Our Case Number: ACP-324410-26

An
Coimisiún
Pleanála

Re: Proposed West Clare Railway Greenway Section 1: Kilrush to Kilkee Project
Kilrush to Kilkee via Moyasta, Co. Clare

Re West Clare Railway Greenway
Section 1

INDICATIVE CROSS SECTION FOR SHARED ACTIVE TRAVEL ROUTE AT MOYASTA BRIDGE CAUSEWAY SCALE: AS SHOWN

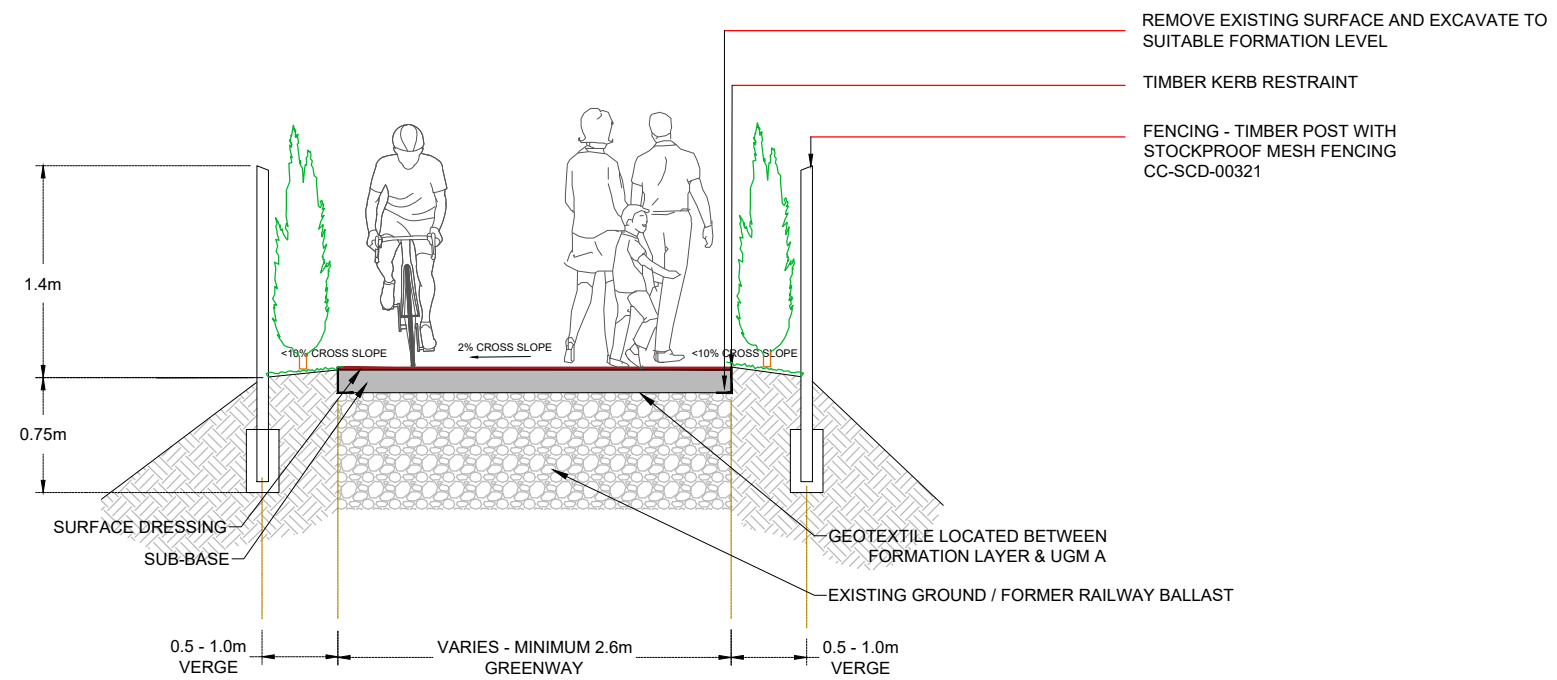
I have serious "concerns" of
the "Red Bridge" section of
the greenway that affects me.
It is my only right of way
to my lands of Folio NO 4563F
Clare county council
and Roughan & O'Donovan are
aware of this problem
for the last 5 years, and still
no workable solution has
been reached on my safe
passage over the bridge and
embankment. The safety of

myself, family members and contractors, Vets, A.I. operator or Department officials could be at RISK on those occasions people and especially children would be at serious "RISK"

The embankment is 2.6 meters wide and farm machinery can range up to 2.55 wide? Fencing 1.4 meters high has to go at each side of greenway, nowhere to escape or to matis

Lots of inconveniences will fall on ~~me~~^{me} and my son in the future. Open and close three gates on the way in and avoid greenway users for over 300 meters and the return journey will

Be the same with the added bonus of having to clean any soil or dirt carried by machinery 300 meters by "good exercise won't take long"
